OXFORDSHIRE COUNTY COUNCIL'S RESPONSE TO CONSULTATION ON THE FOLLOWING DEVELOPMENT PROPOSAL

Application no: 22/00747/OUT

Proposal: Outline planning application for the development of up to 370 homes, public open space (including play areas and woodland planting), sports pitches and pavilion, drainage and engineering works, with all matters reserved (appearance, landscaping, layout and scale) except for vehicular and emergency accesses to Bicester Road.

Transport Schedule

Articulated Vehicle Entry North
1:500

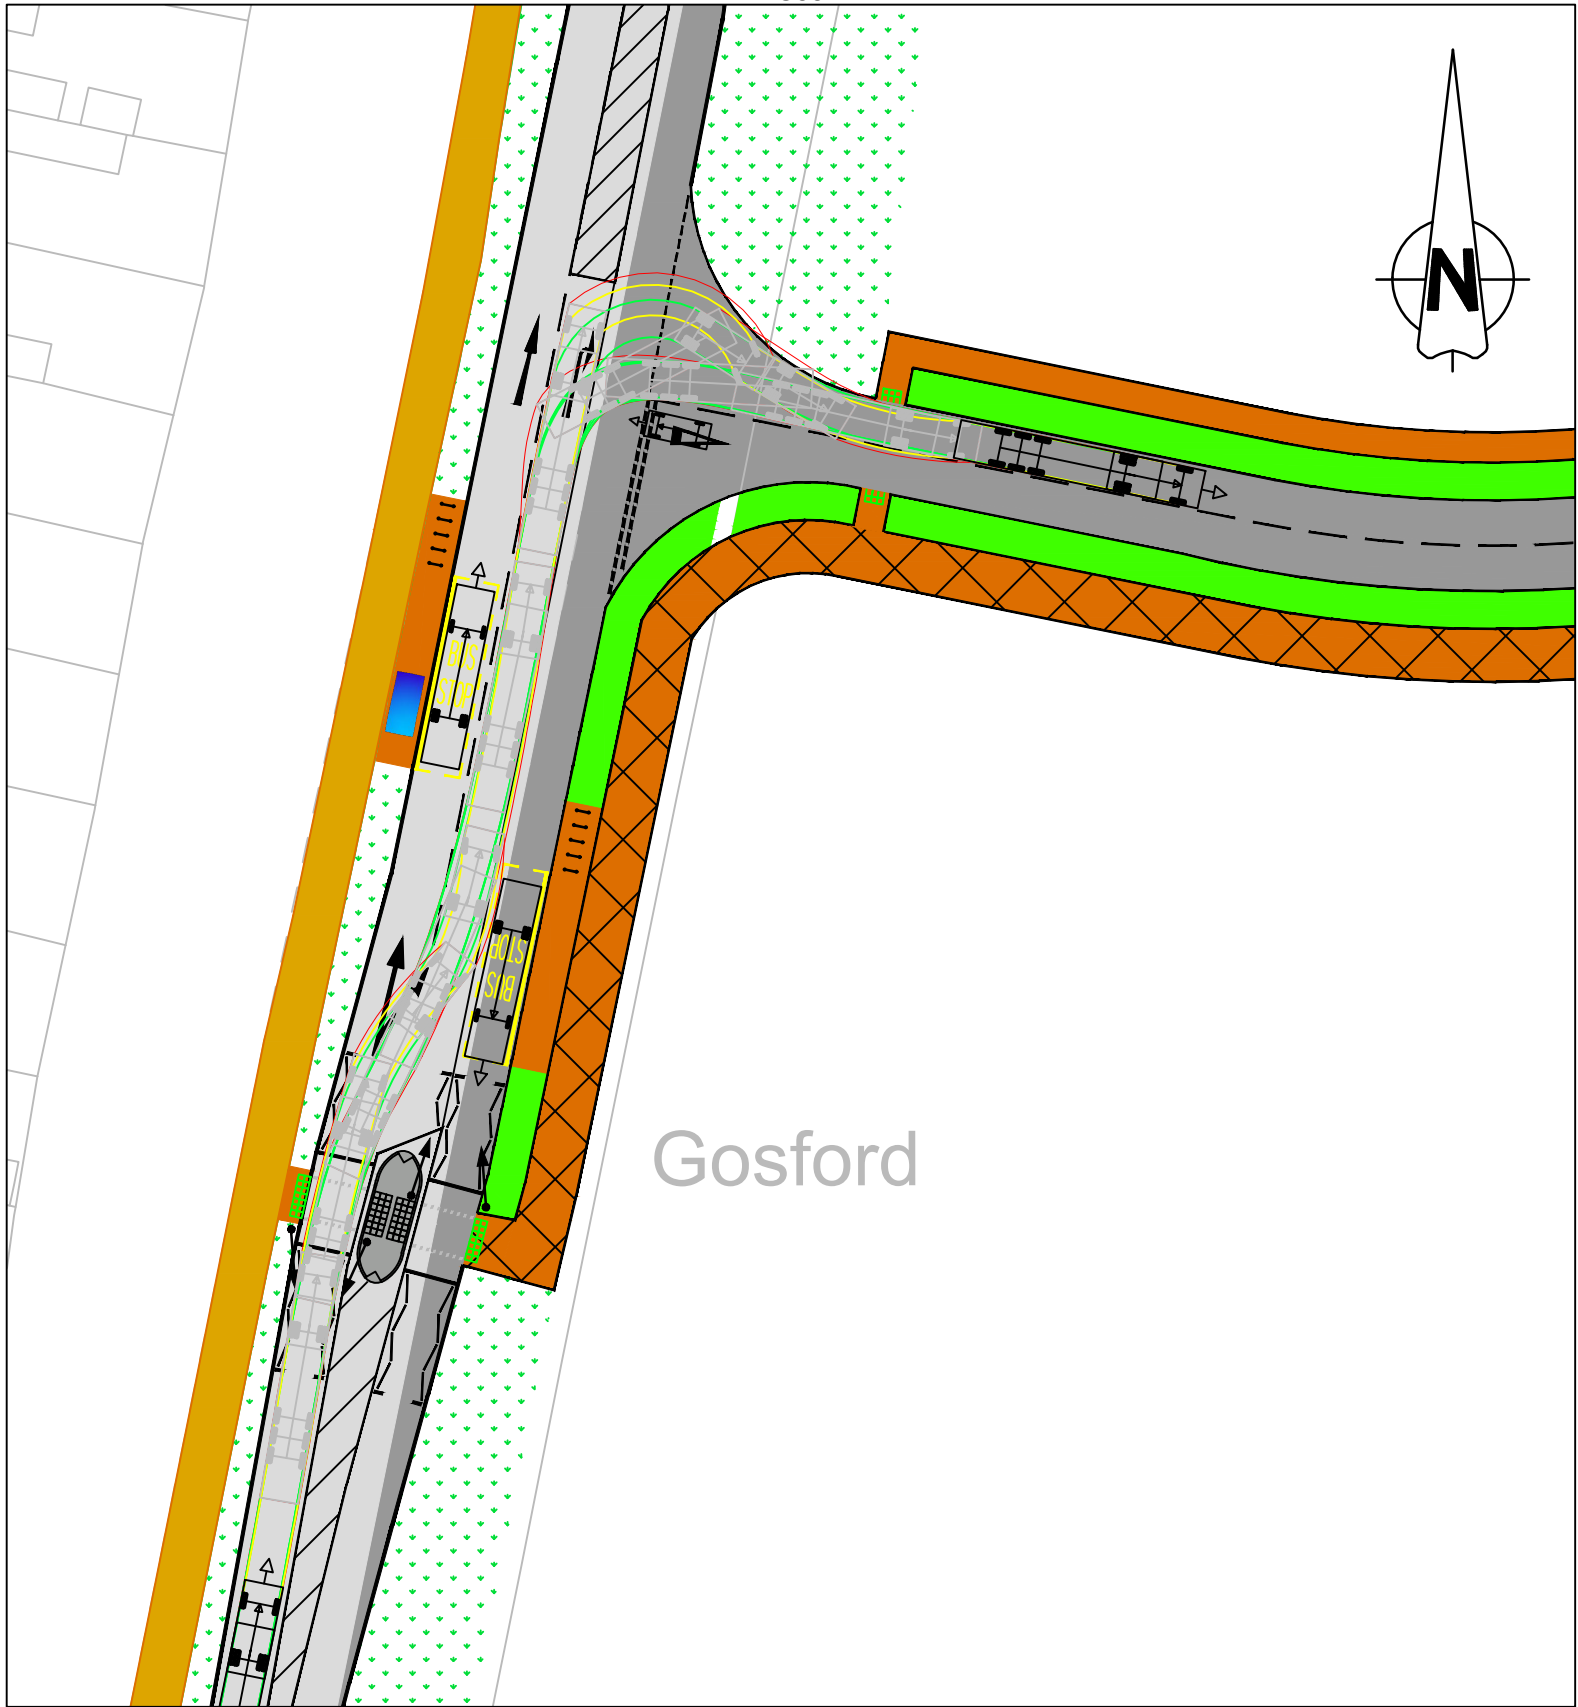
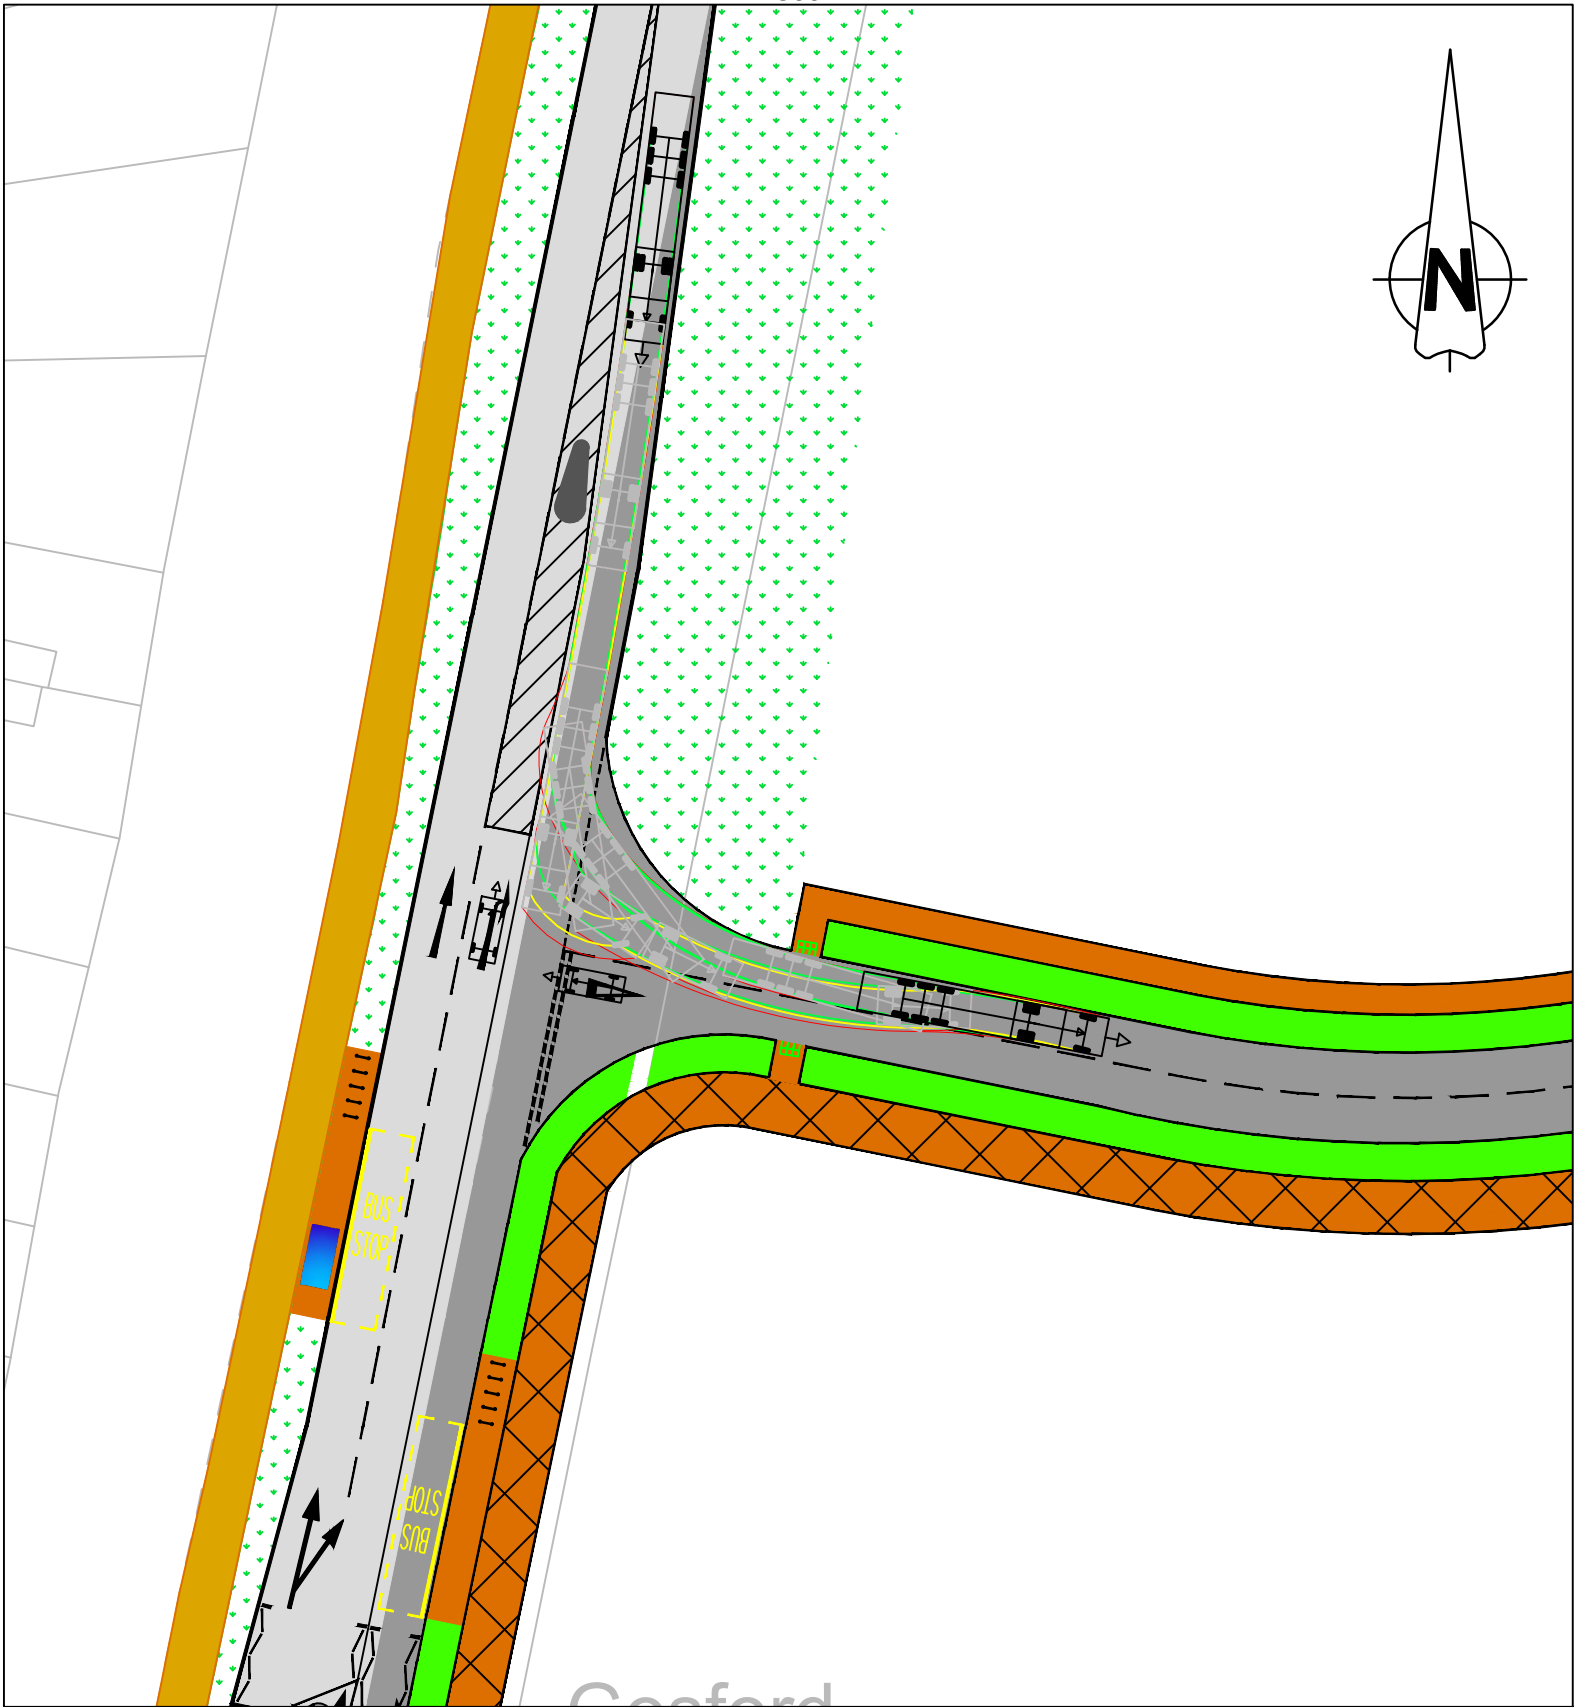
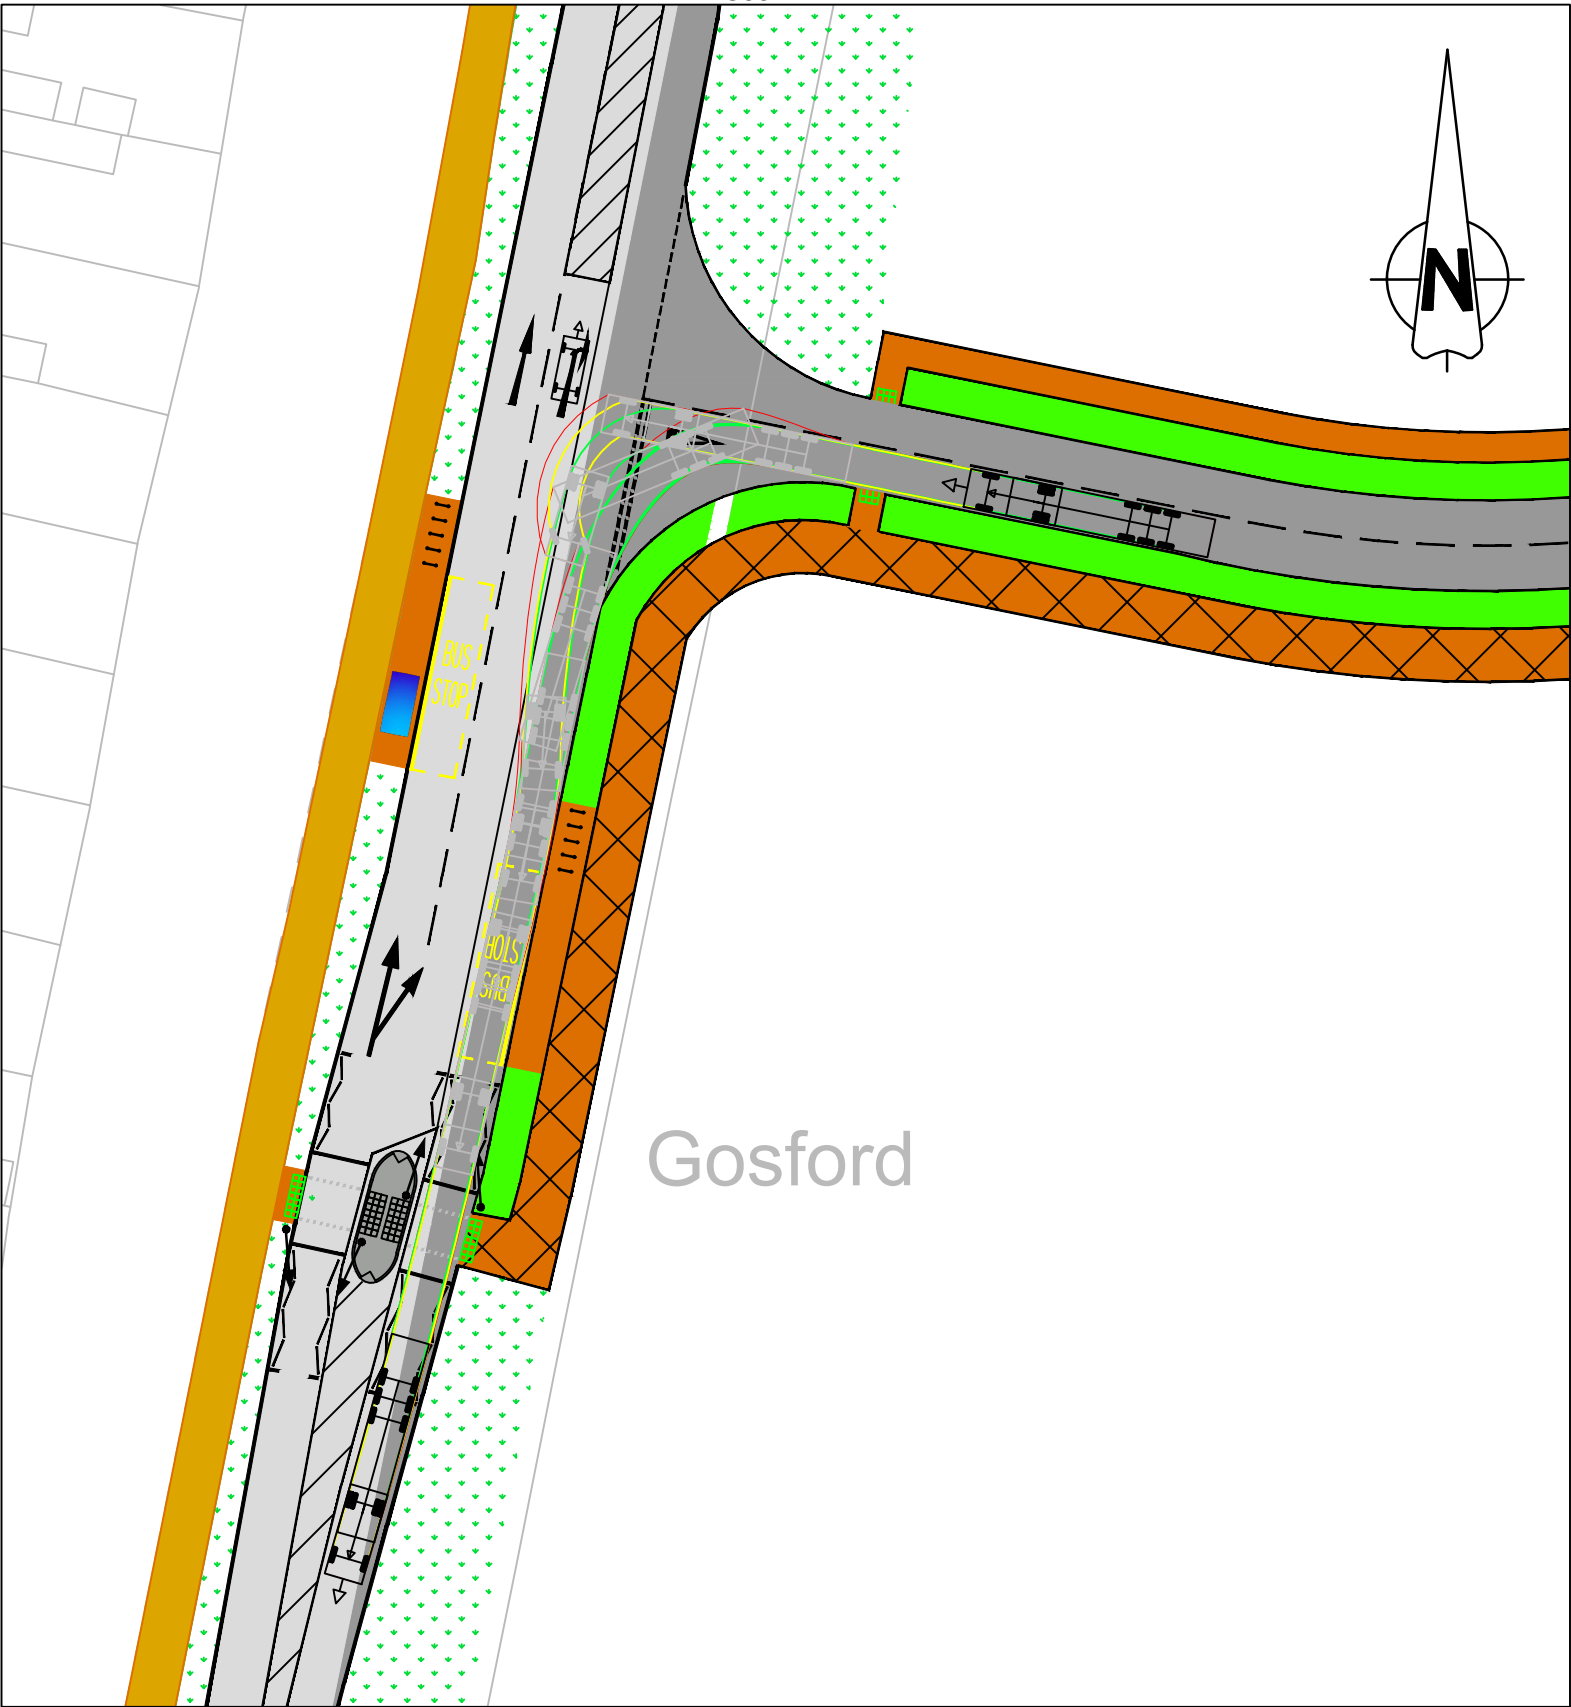
In our previous report, I noted through the submitted tracking drawings that the access geometry could not safely accommodate large vehicles without infringing into oncoming traffic particularly for the right turning lane. While the width of the access road has been increased to about 6m wide for the first 10metres, this has not improved the prevailing concern of affected incoming vehicles rather than the left turning vehicles. The tracking exercise on the revised junction still presents the same conflict between right turning arrivals and left turning exiting traffic.
